Subject: FW: 23/00862/FUL Flats above 6 Church Green West extn of time to 23 Dec 2023

From: Sharron Williams - Principal Planning Officer <sharron.williams@bromsgroveandredditch.gov.uk>
Sent: Monday, November 13, 2023 12:24 PM
To: Clive Berry <
Subject: 23/00862/FUL Flats above 6 Church Green West

FIRST FLOOR PLAN

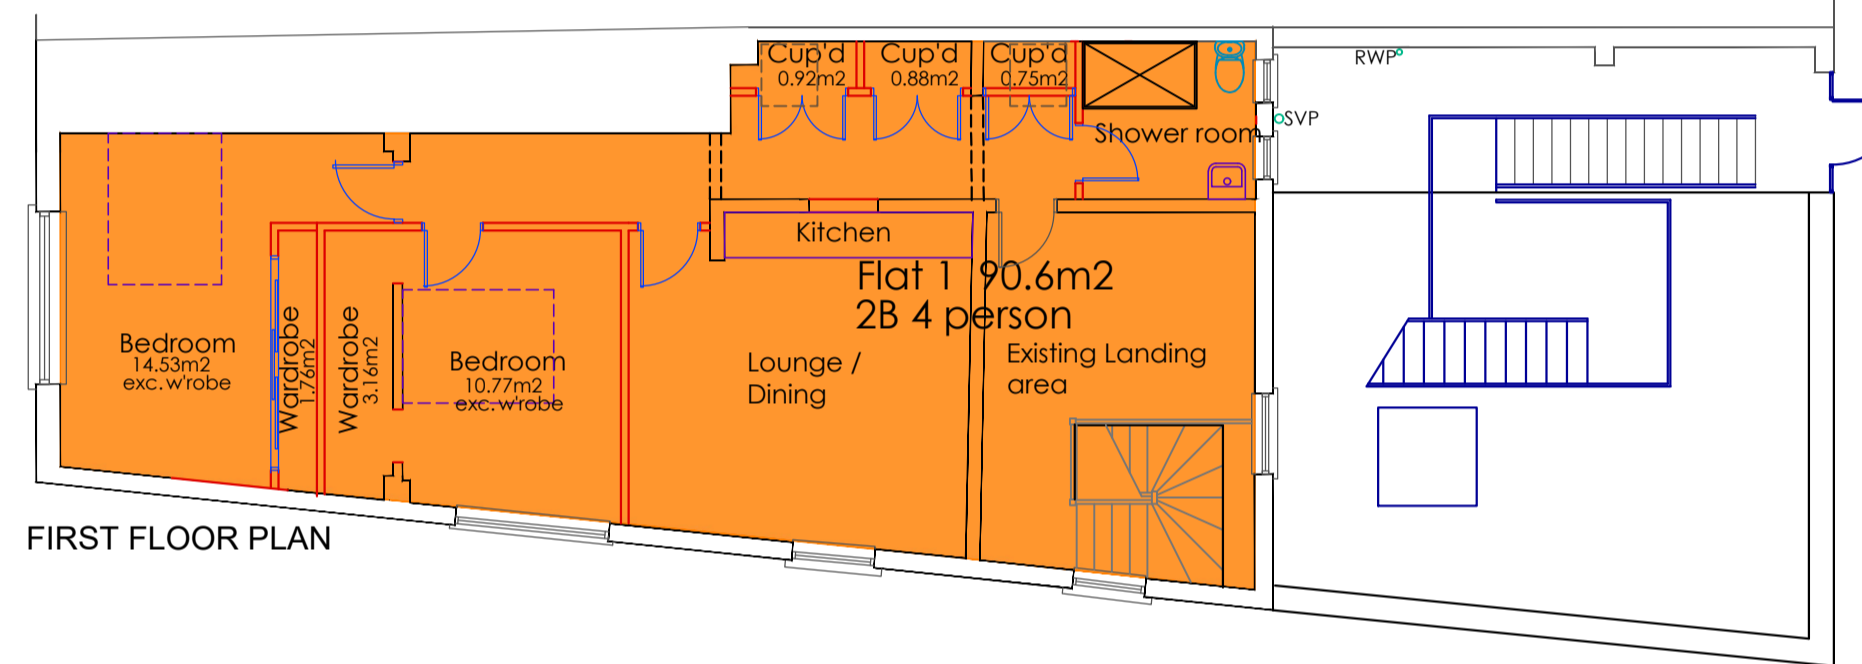
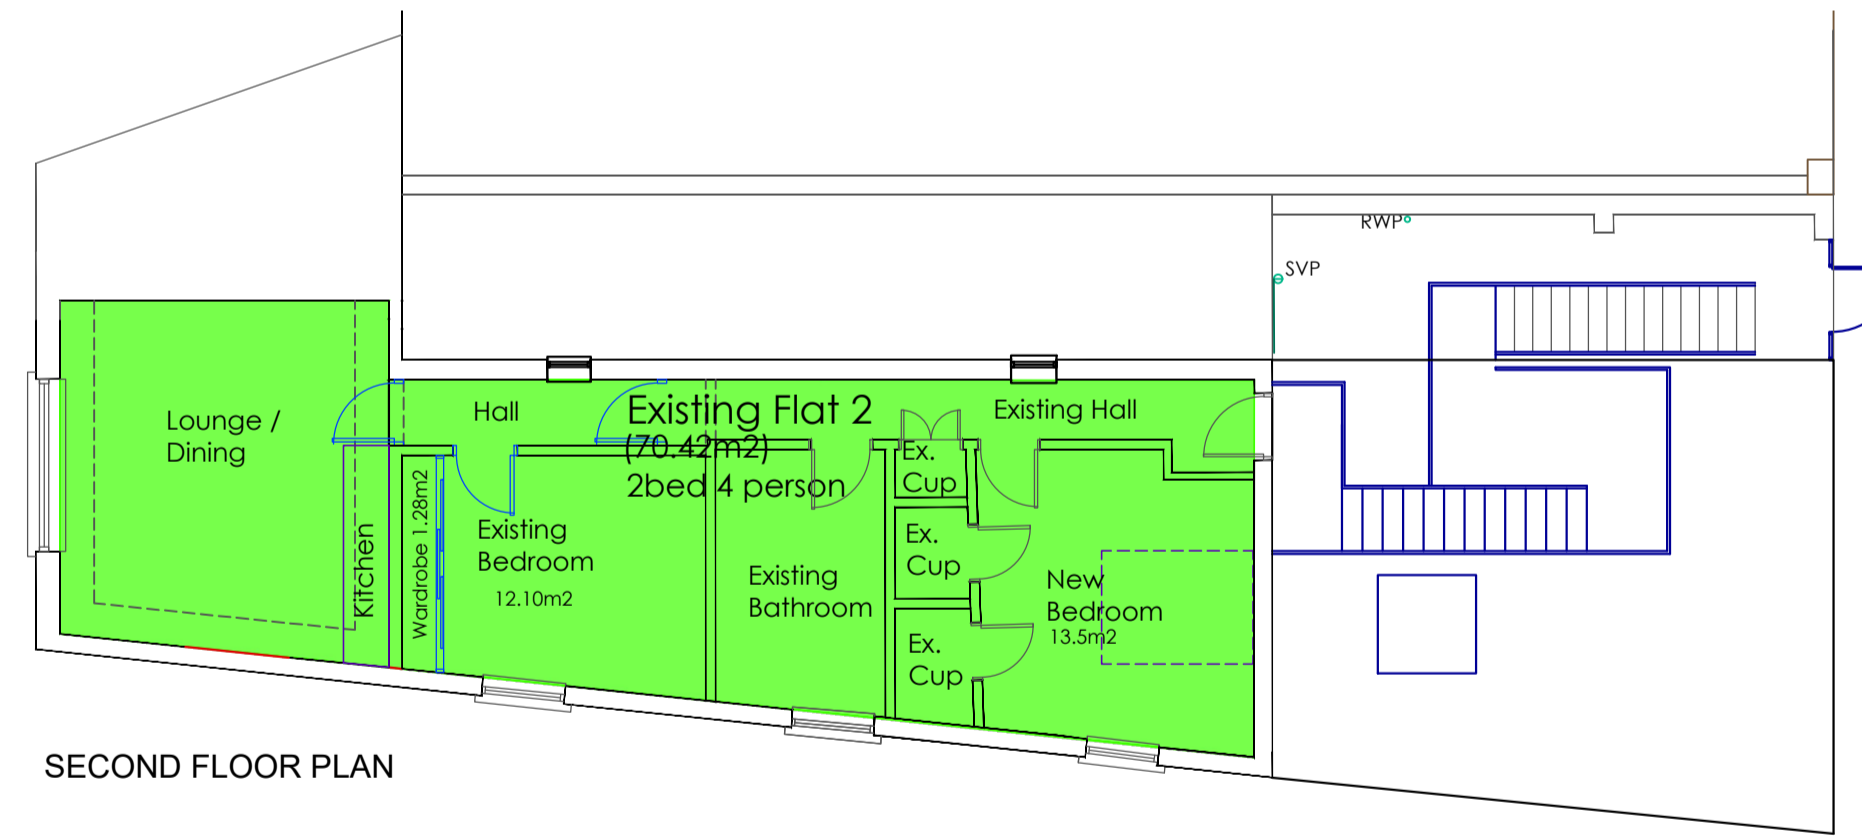
I note that flat 4 is the smallest flat out of all of them. Having checked the floorarea, I would consider that the floorarea is closer to 46sq metres approximately, and as such would not comply with the DCLG Technical housing standards – nationally described space standard document for a 1 bedroom 2 person flat.

For the above reasons I would recommend that the proposal be reduced to a 3 flat scheme, omitting flat 4 resulting in extension on the first floor only, which will provide a break in the overall height of the building on the side elevation, and would be of a similar mass to the building opposite (7a Church Green West).

I have re-checked the area of flat 4 on the computer and it is 50m² which does comply with the DCLG guide, so I am unable to understand how you arrive at 46m² and I'm afraid I have to admit I am rather more favoured to what my computer tells me than what your manual calculation says.
